INSPECTION REPORT

PROJECT NAME: Tidal Wave Auto Spa

LOCATION: Unser Blvd. NW & Bandelier Drive NW, Albuquerque, New Mexico, 87114

TYPE OF INSPECTION: 14Day

7

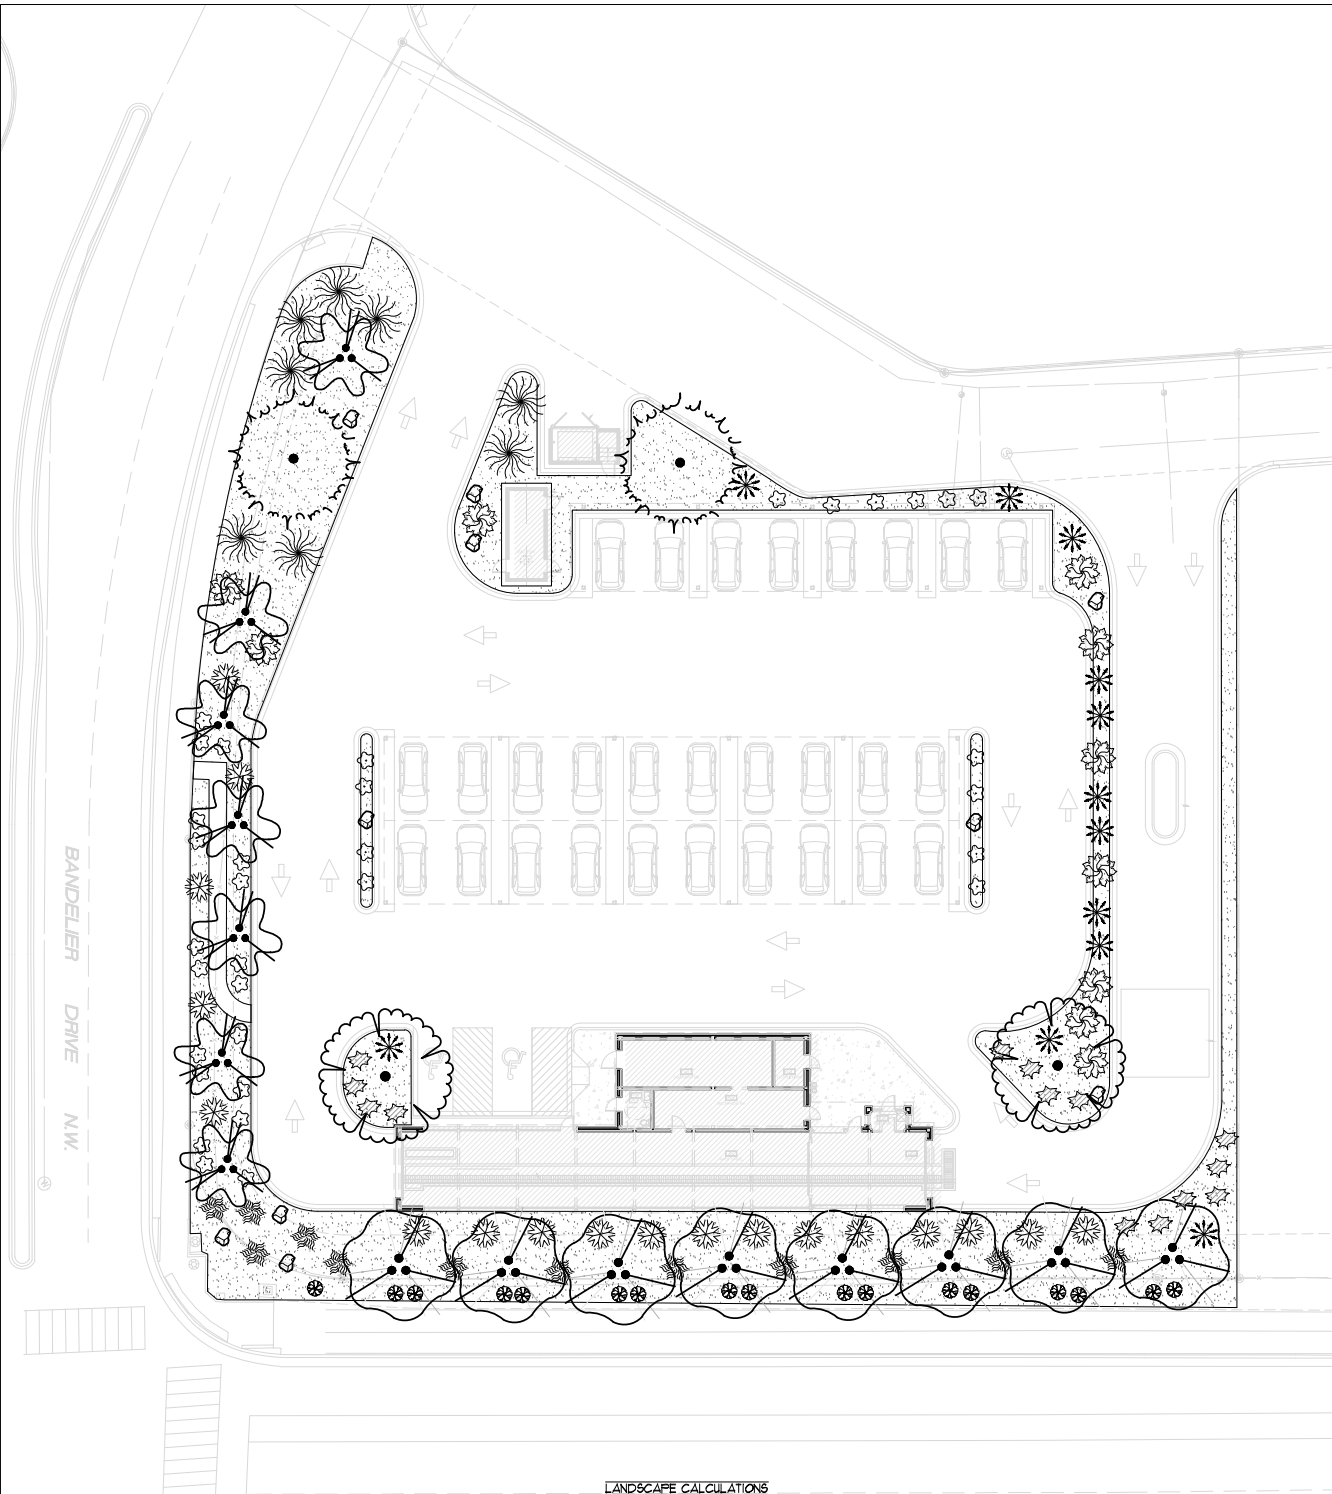
15	Are changes to the SWPPP necessary at this time?	<input checked="" type="radio"/> Yes <input type="radio"/> No <input type="radio"/> N/A	<input checked="" type="radio"/> Yes <input type="radio"/> No	site map will need to include location of posting board, construction entrance, and silt fence.
16	Are dust control measures being properly implemented?	<input checked="" type="radio"/> Yes <input type="radio"/> No <input type="radio"/> N/A	<input type="radio"/> Yes <input checked="" type="radio"/> No	
17	Are the SWPPP documentation and records up to date and accurately reflect the current conditions? (e.g. Site Map, Inspection Reports, Installation Dates)	<input type="radio"/> Yes <input type="radio"/> No <input checked="" type="radio"/> N/A	<input type="radio"/> Yes <input checked="" type="radio"/> No	No one was on site unable to view SWPPP book during inspection
